Final Report - Corrections Required **Application No. SUBD-26-0048**

Description : Single family residential with optional ADU. 41 lots

Document Filename : FP Creekridge at Flying Horse Filing No. 2 26 0519.pdf

CITY FILE NO. SUBD-26-0048

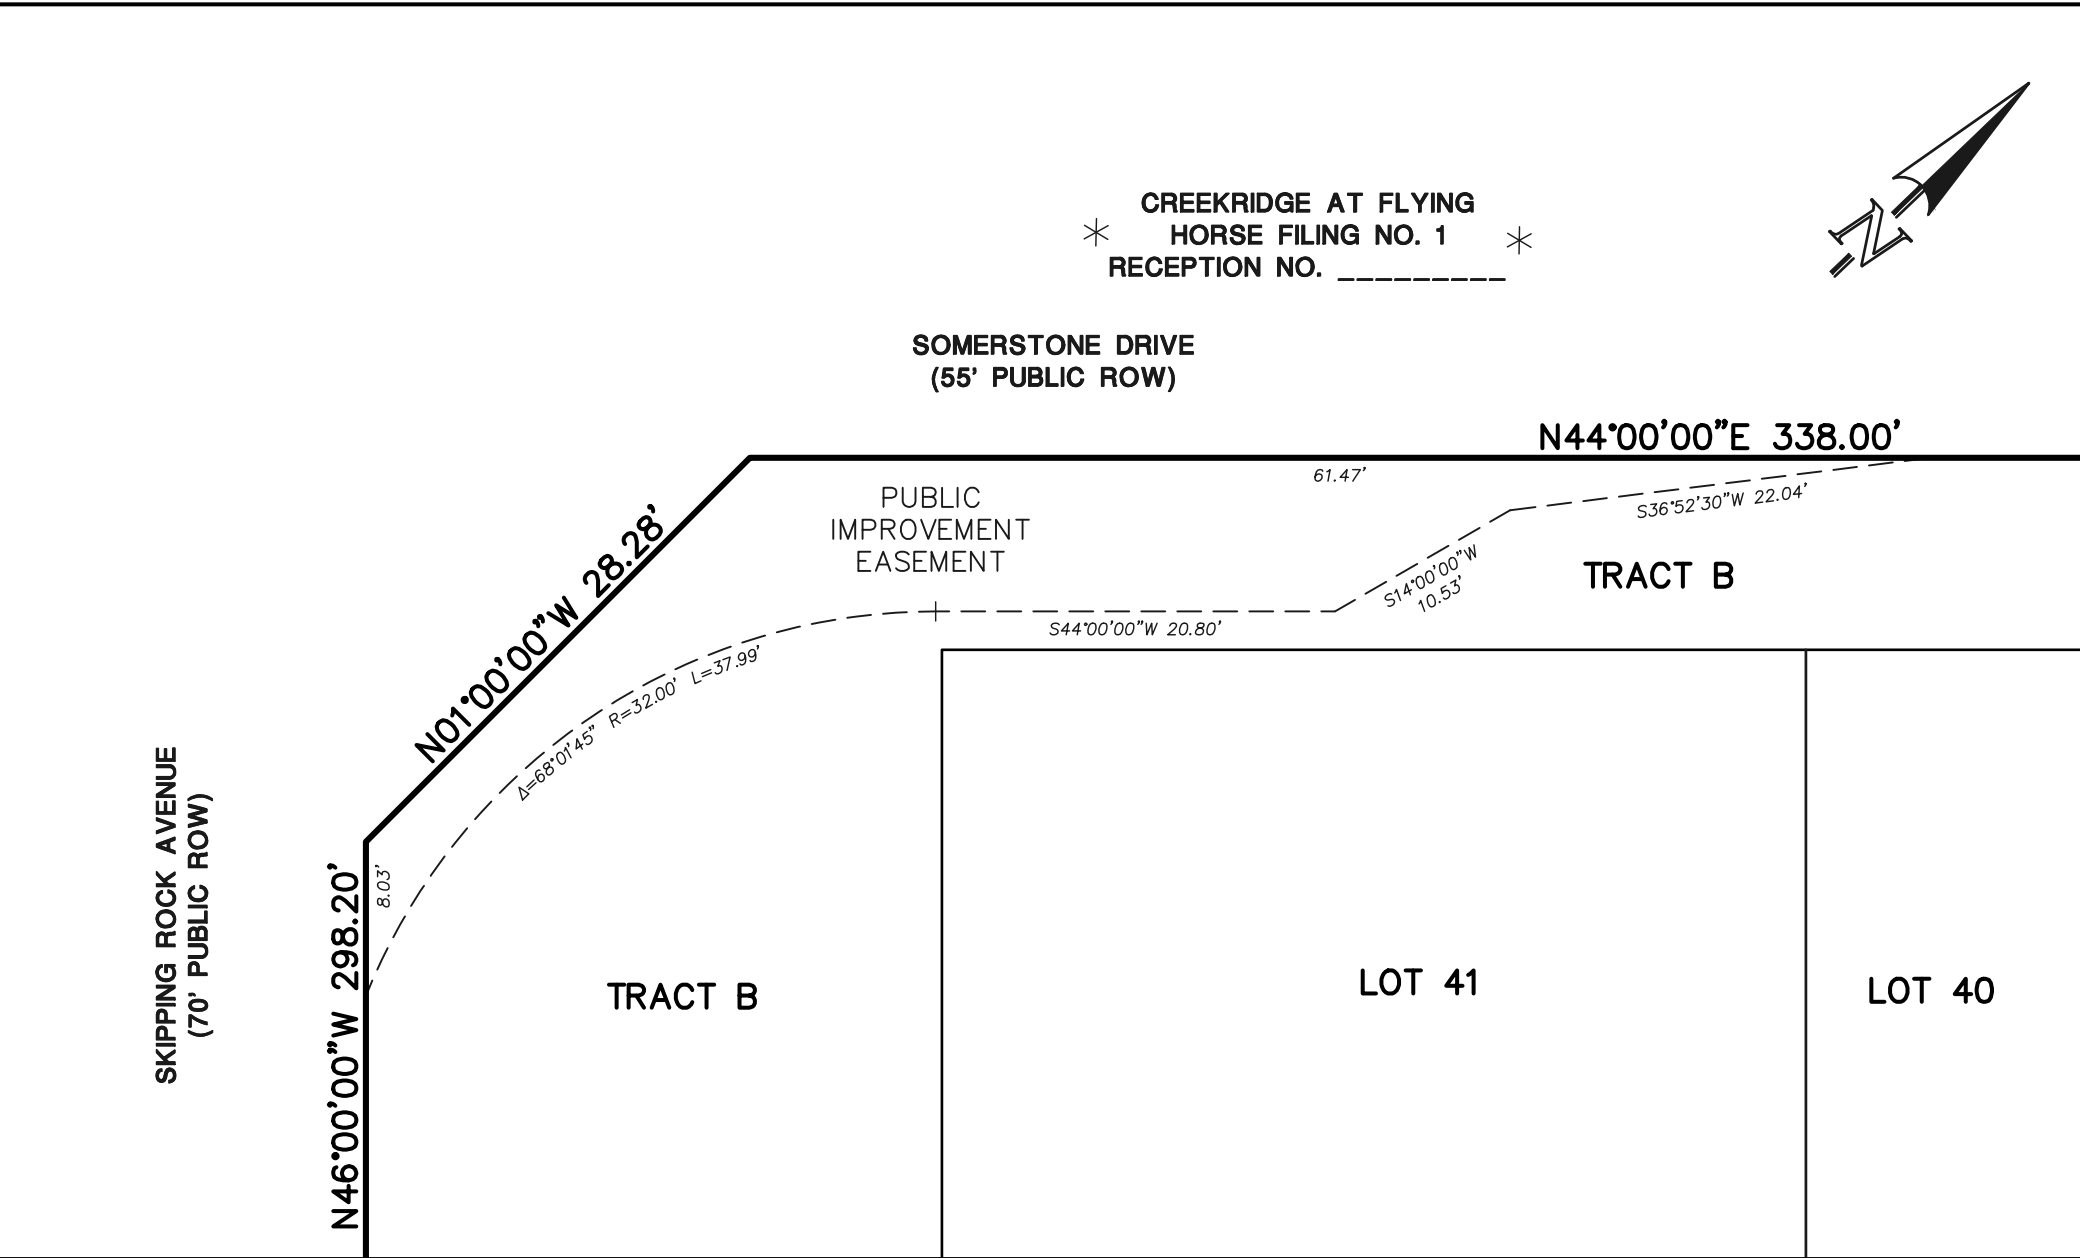
21	12	Matthew Alcuran : Col Springs Utilities	Show and label existing 75' public utility easement under Book 1623 Page 610 to ensure no conflict.
37	11	Caroline Miller : Planning	Informational - As detailed by District 20 on DEPN-26-0068, the School Fee box will be notated as 'Due at Building Permit' by staff on plat mylar.
38	11	Caroline Miller : Planning	Staff requests second review before confirming Park Fee box, after applicant meeting as detailed with DEPN-26-0068.
39	11	Caroline Miller : Planning	Citywide Development Impact (Police & Fire) Fees will be due as detailed with DEPN-26-0068, with fees due for both SFH and ADU option at time of building permit as selected.
19	12	Michelle Lavelle : Planning	Street names - Lunar View Lane needs to be corrected. Lunar Vine Lane was reserved. All other Street names are spelled correctly and appropriate use of suffixes for public streets.
40	12	Allison Stocker : Planning	Comments from El Paso County and USAFA will be passed along if/when received

41	12	Allison Stocker : Planning	Similar to Filing No 1, please make sure adequate sidewalk connectivity is provided along roads and provide easements as appropriate
24	11	Barbara Reinardy : Real Estate Services	Please specify which lettered tract is being dedicated to the City. If there are none, please remove "tracts".
26	11	Barbara Reinardy : Real Estate Services	On both sheets: SUBD-26-0048
27	11	Barbara Reinardy : Real Estate Services	Please expand the name of the document: "Amended and Restated Declaration of Covenants, Conditions, Restrictions and Easements for Flying Horse Commercial per Rec....."
28	12	Barbara Reinardy : Real Estate Services	In a numbered plat note, please explain what a private use easement is, which cannot be dedicated by this plat, and can only be granted by a separately recorded easement document.

Comment ID	Page Reference	Reviewer : Department	Review Comments
29	12	Barbara Reinardy : Real Estate Services	Please correct the typeovers
30	12	Barbara Reinardy : Real Estate Services	Is it necessary to have a public utility easement across a public ROWs?

Please specify which lettered tract is being dedicated to the City. If there are none, please remove "tracts".

Please expand the name of the document: "Amended and Restated Declaration of Covenants, Conditions, Restrictions and Easements for Flying Horse Commercial per Rec....."
